**STATUTORY PLANNING CONSULTATION RESPONSE**

<b>Application Number:</b>	3/2026/0214
<b>Proposal:</b>	Proposed erection of 26 affordable dwellings with associated access, gardens, parking and landscaping.
<b>Location:</b>	Land at Albany Drive Copster Green BB1 9EH

**Objection 01 – Inadequate Surface Water Sustainable Drainage Strategy**

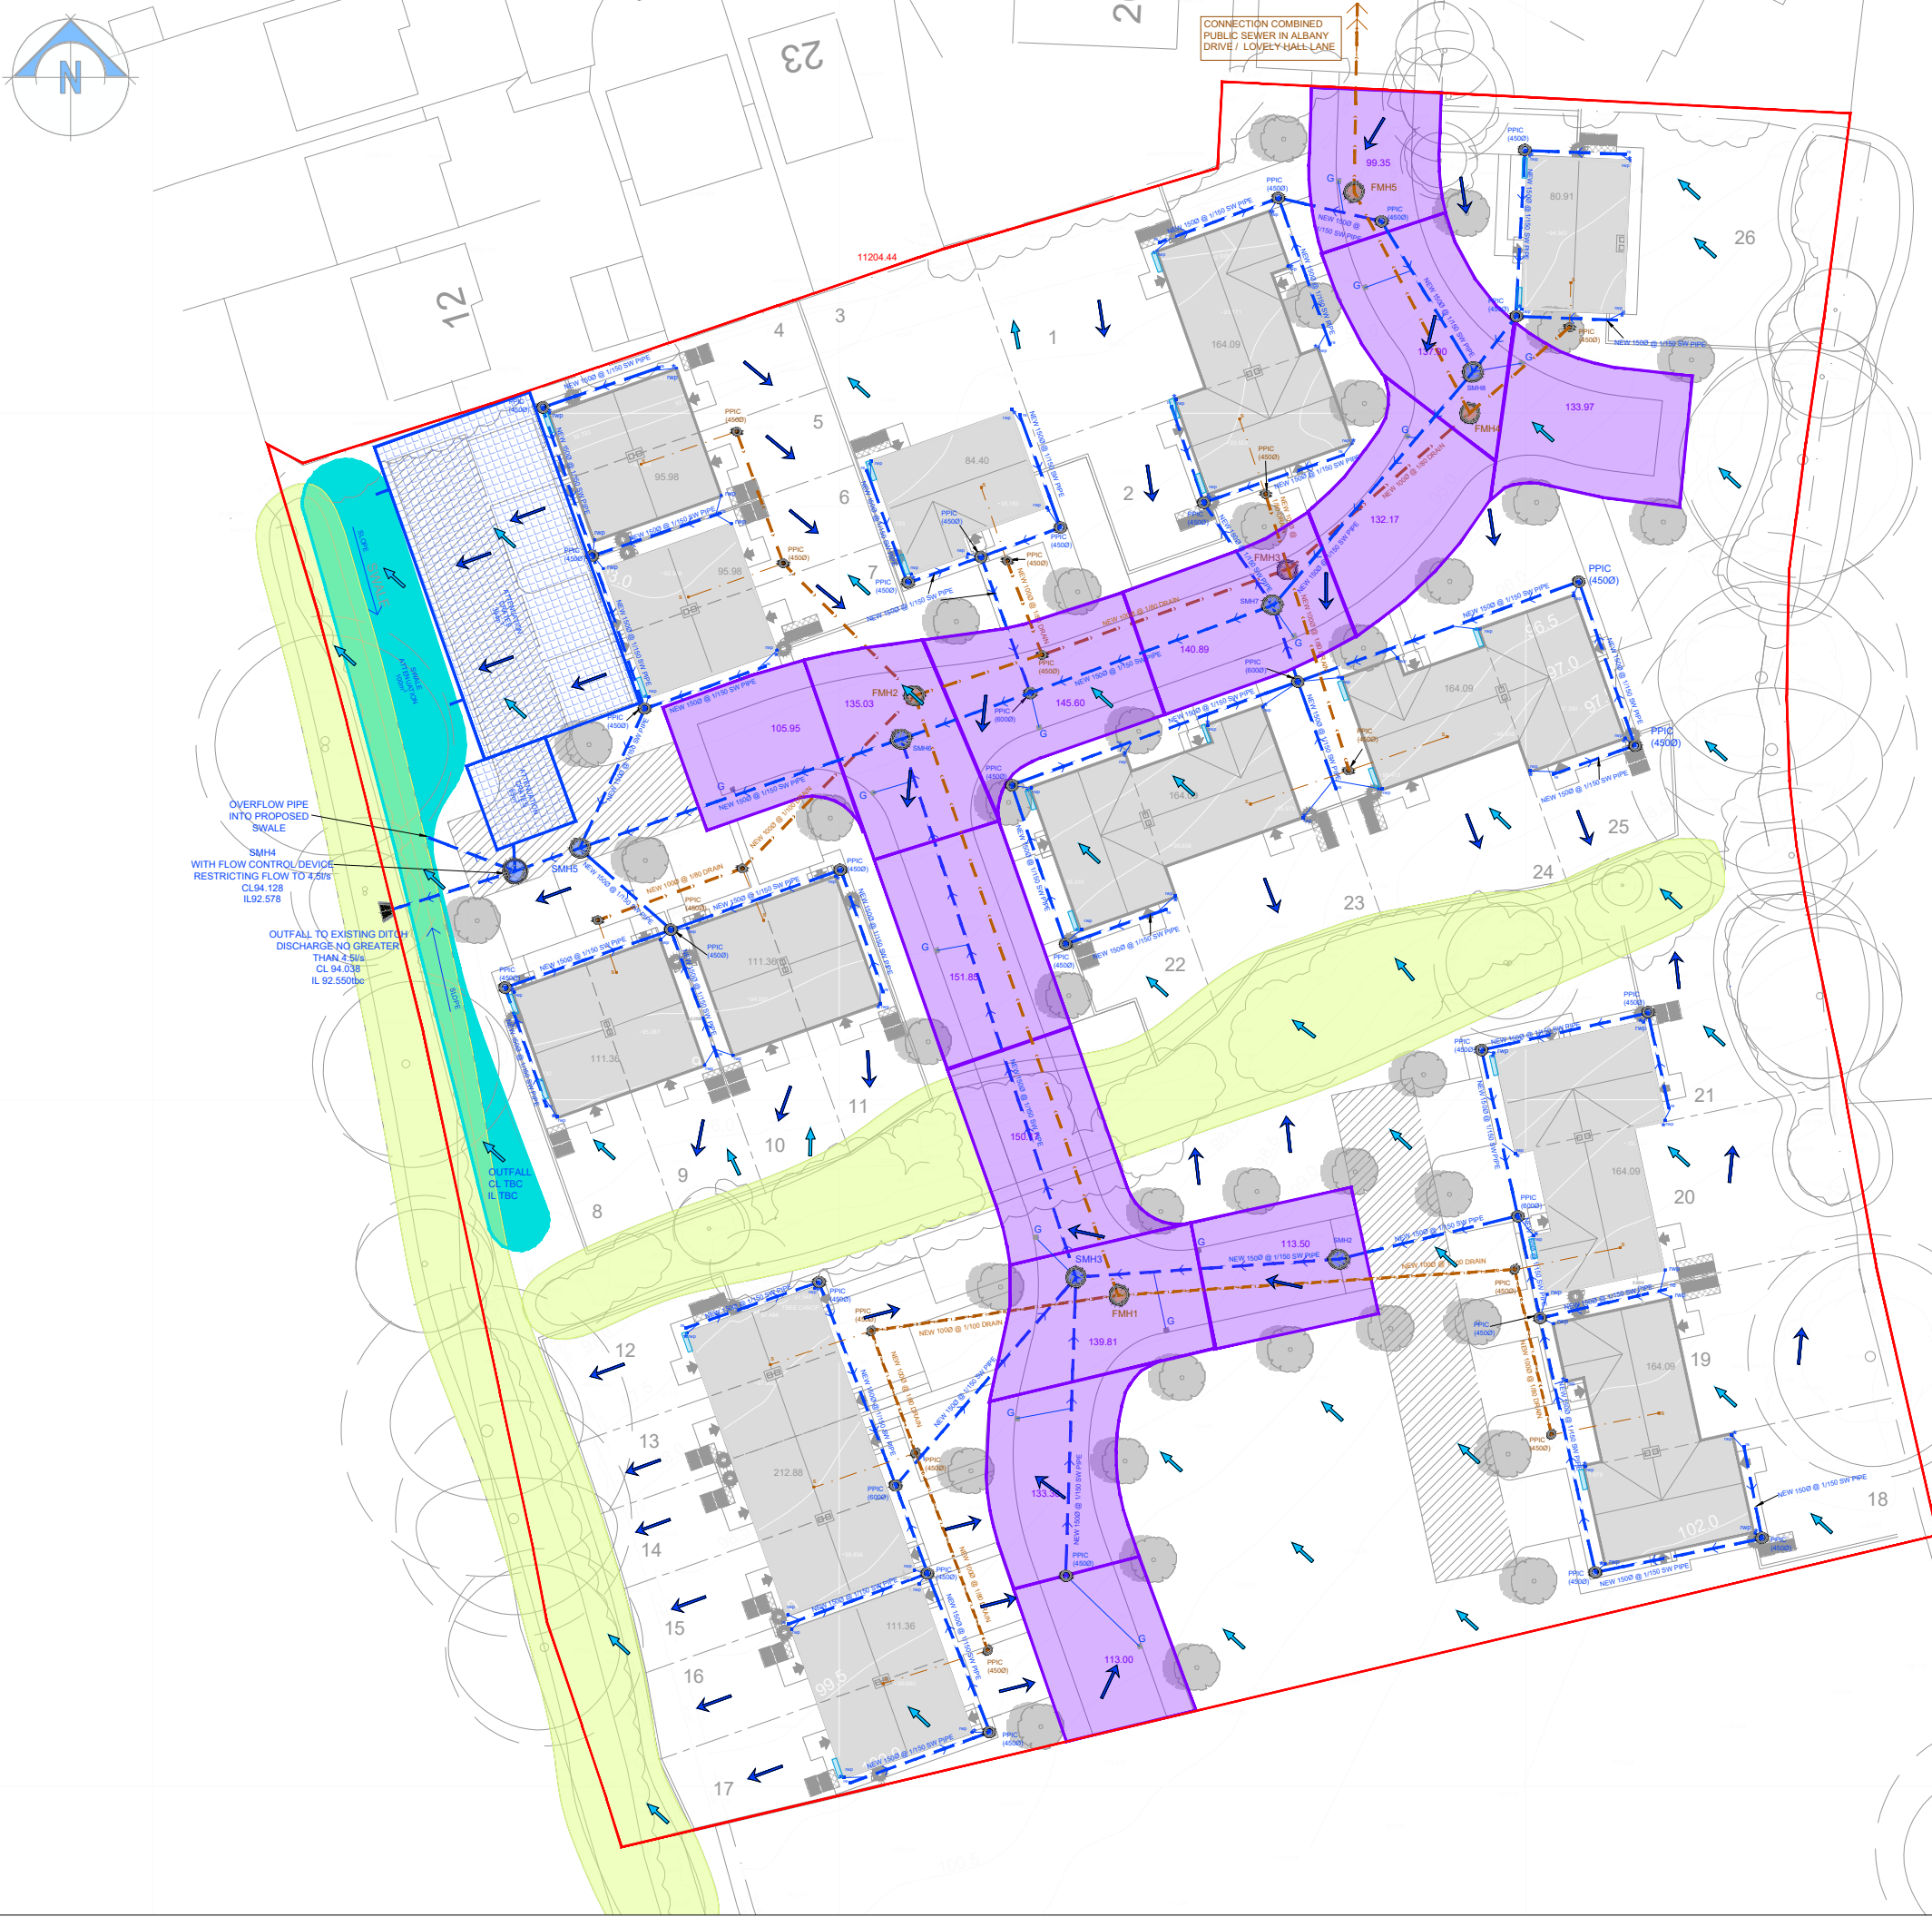
- The submitted drainage strategy sizes the SuDS based on a greenfield discharge rate of approximately 9l/s (which is based on the whole site area), but has proposed to discharge surface water at approximately 3l/s, therefore meaning that the suds are potentially undersized.

The applicant must design their SuDS with an appropriate estimation of the area contributing to the drainage system, both permeable and impermeable, with evidence of this area provided through an appropriate contributing area plan, or otherwise demonstrate how surface water runoff from non-drained areas will be managed without contributing to the drainage system and without increasing flood risk onsite or elsewhere. For the avoidance of doubt, the runoff area used in any of the runoff estimation methods should be consistent.

Should infiltration not possible on the proposed development and, therefore, while these areas, such as gardens, roadside verges and areas of public open space, may not be positively drained, they may contribute indirectly to the drainage system during extreme events.
